Kittenash
Hook Lane
Aldingbourne

21st October 2016

Re: AL/107/16/RES

I object to the above application on the following points:

Drawing Title:-
**STREET LIGHTING
LAYOUT**

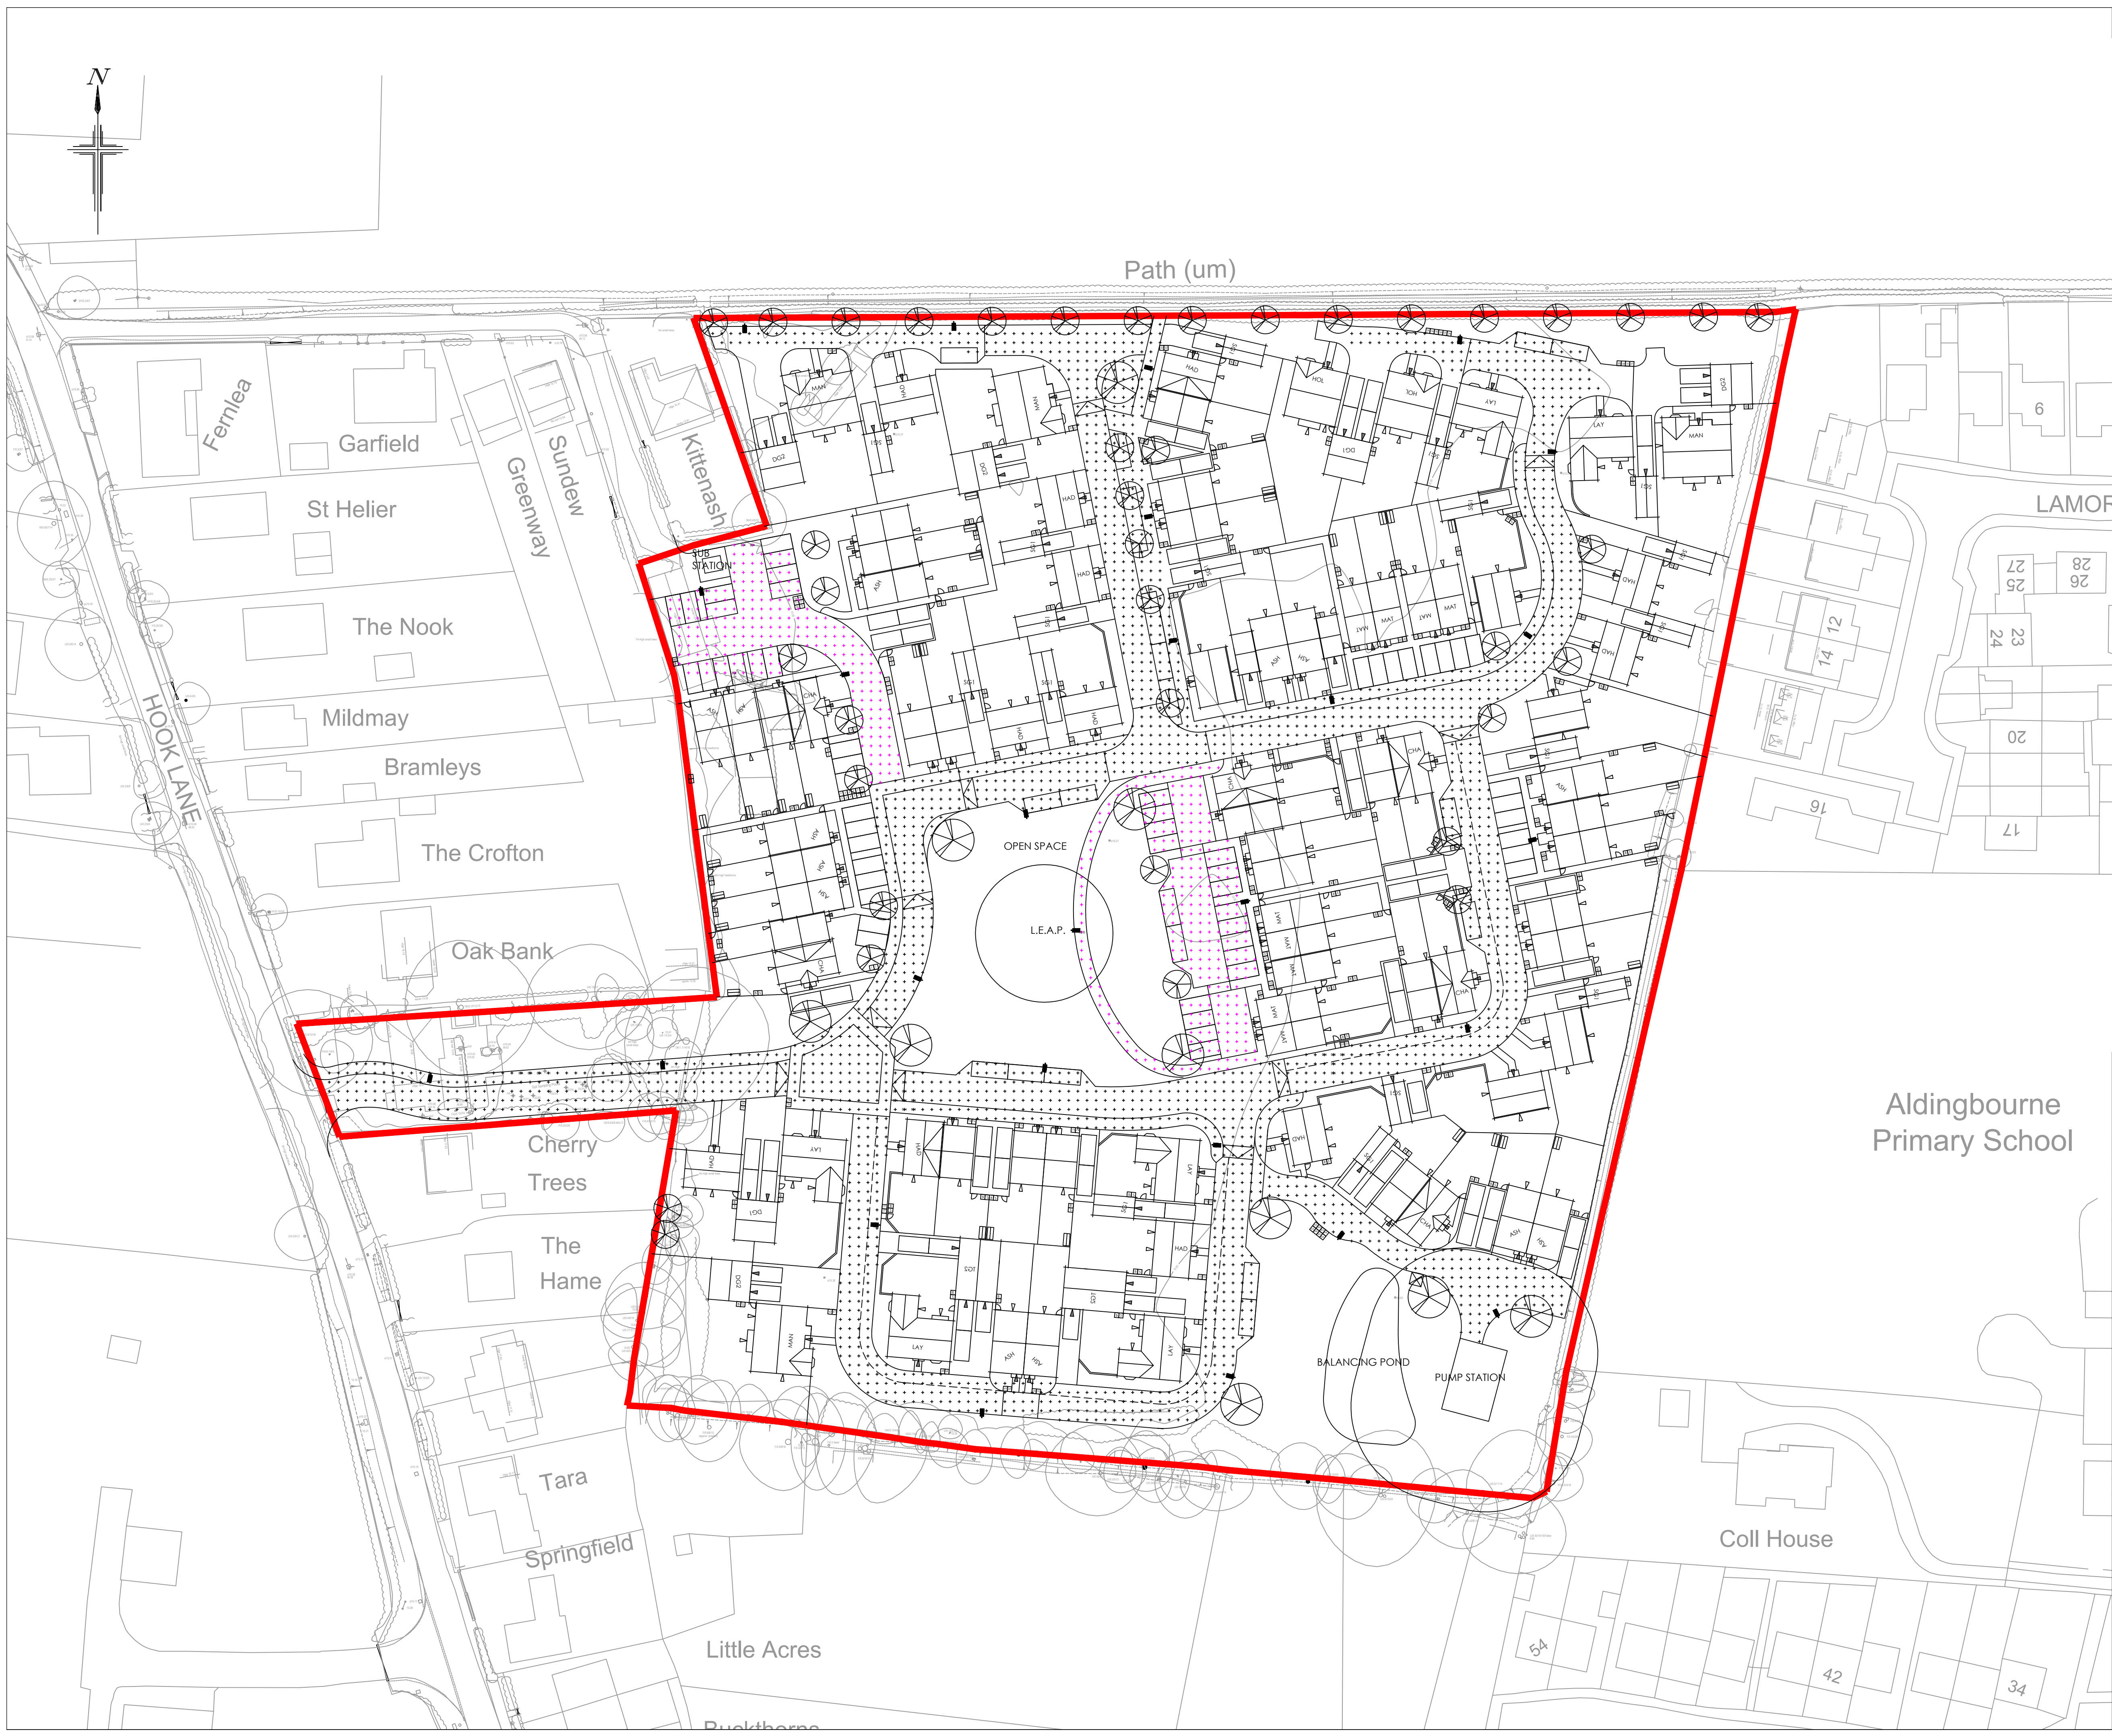
The proposal for a street light to be placed in the north east corner, to the front of plot 19, will be detrimental to my property and is not needed as there is no foot flow and the road way only leads to the garage of plot 19. Any street light in this location will give light directly into my property.

The proposal for a street light in the parking area at the bottom of my garden will spill light into my back garden and should therefore be removed from the plan. There is a proposed street light on the corner of plot 9 which will give light to this area.

BDWS20440-03

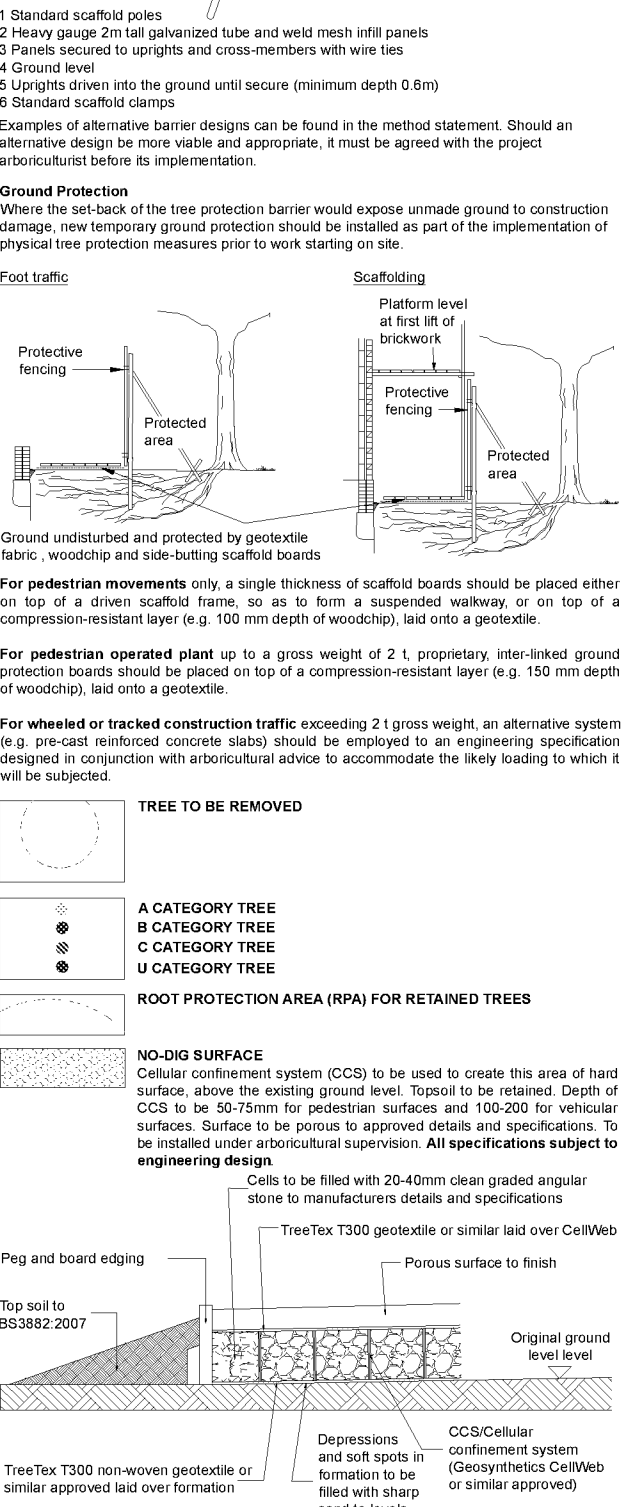
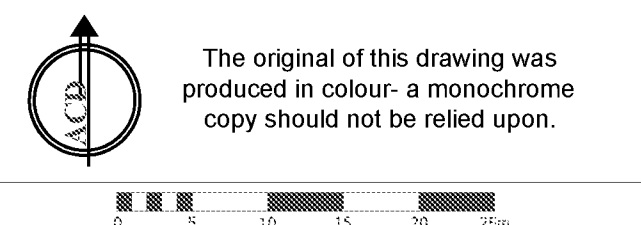
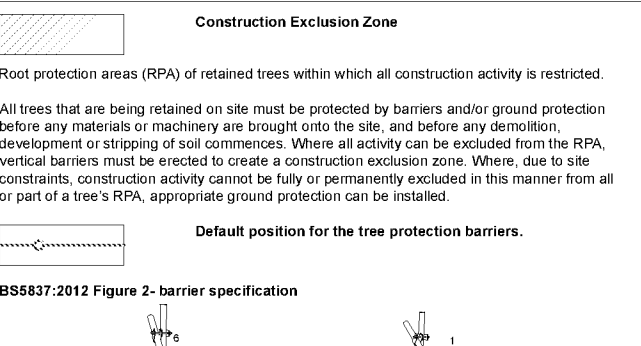
At the bottom of my garden, 3.50m away from and in line with the Silver Birch, is a mature specimen Eucalyptus tree which has not been included in the tree report although this is a large tree. No allowance for the root protection area of this tree has been taken into account. Photo attached to show location.

Approximately half way down the garden, just inside the boundary, is a mature Crataegus of approximately 4.5m height. This tree has also not been included in the tree report and its location is in the area which would appear to be where the garage for plot 19 is proposed.
